Application by NNB Generation Company (SZC)
Limited for an Order Granting Development
Consent for The Sizewell C Project

Planning Inspectorate Ref: EN010012

Summary of Oral Representation at Issue
Specific Hearing 10 on Biodiversity and Ecology

Submitted for Deadline 7 (03 September 2021)

DRAWING TITLE:
 FIGURE 1.1
 WESTLETON MARSH HARRIER COMPENSATORY HABITAT LOCATION

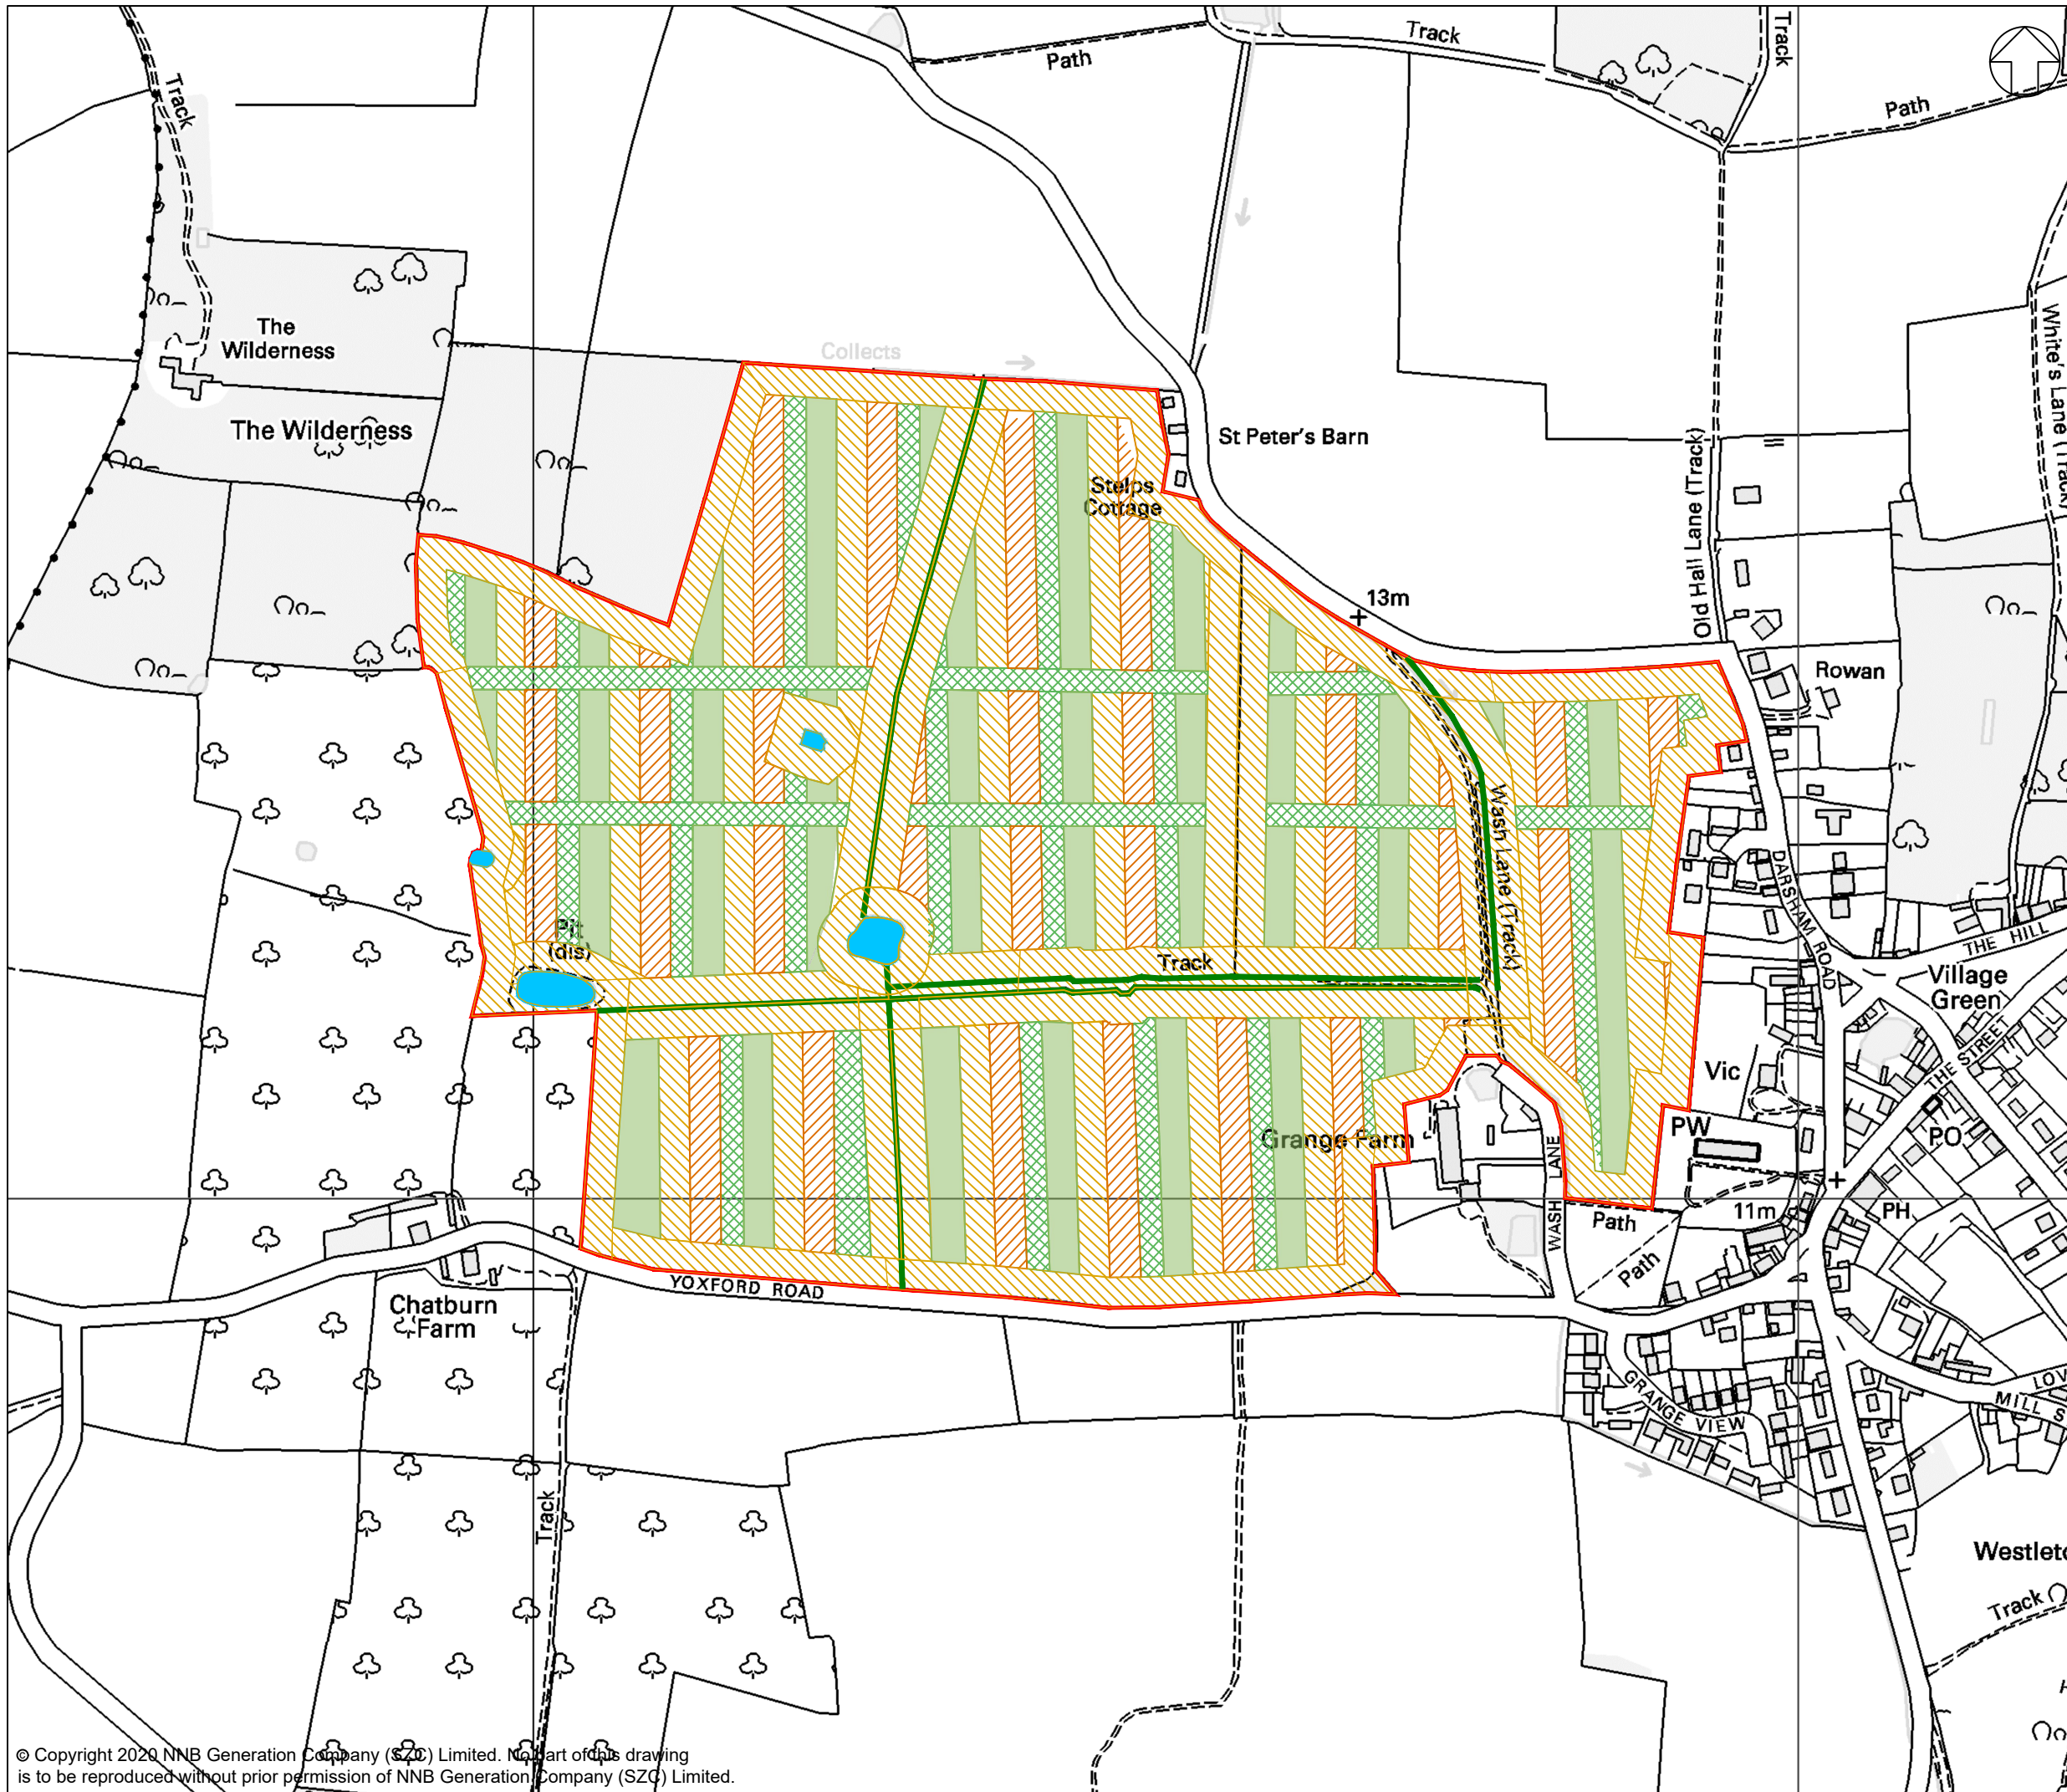
7. Since the above input was made at the Compulsory Acquisition Hearing (CAH), Mr Horton did not go into detail on the ecological matters.
8. I seek to bring to your attention a comparison of the parcel of land at Westleton (the Applicant's compensatory land proposal) and the parcel of land at Theberton (my client's compensatory land proposal). I will make that comparison using the criteria as listed in REP6-002 Appendix B, Section 4.2 '*Selection of the proposed Westleton site*', noting that this information was not available to my client's representative (Mr Horton) at the CAH.

Criterion	Option			
	Theberton		Westleton	
	Description	Relative score	Description	Relative score
The six criteria set out by the Applicant in REP6-002				
Not designated for existing ecological value or part of RSPB reserve	Yes	=	Yes	=
Proximity to Minsmere reedbeds (within 4 km).	2.0 km	+	3.5 km	-
Arable or (low ecological value) sown pasture areas	Yes	=	Yes	=
Single contiguous site	Yes	=	Yes	=
Avoiding popular footpath and other rights of way	No	=	No	=
Hedges, ditches and varied topography	Yes	=	Yes	=
Total of relative scores		+1		-1

Criterion	Option			
	Theberton		Westleton	
	Description	Relative score	Description	Relative score
Additional criteria identified and relevant to marsh harrier ecology				
Area	50+ ha	=	54 ha	=
Proximity to wetland habitat within SSSI	0.0 km	+	1.4 km	-
Potential for grass / gamecover mix	Yes	=	Yes	=
Potential for wetland creation	Yes	+	No	-
Adjacent to settlement / village	No	+	Yes	-
Public right of way within the parcel	Yes	=	Yes	=
Stewardship agreement on land parcel	Yes	-	No	+
Total of relative scores		+2		-2

10. From the above it can be concluded that the Theberton land is superior to the Westleton land when tested against:
- The criteria that the Applicant has published, and

12. The Applicant's submission document AS-408 '*Note on Marsh Harrier Habitat*' identified that whilst the Theberton land had been included within the long list of sites being considered as potential marsh harrier compensatory land, it was screened out specifically because it was under an agri-environment agreement. I would suggest that was a mistake, an error of judgement, by the Applicant. To screen out the Theberton land was in error for several reasons:

13. My view is clear, the Applicant erred in ruling out the parcel of land at Theberton and that decision should be reconsidered. My clients are keen that the land at Theberton under their control is reconsidered and have met with the Applicant's representatives several times, including making a site visit.
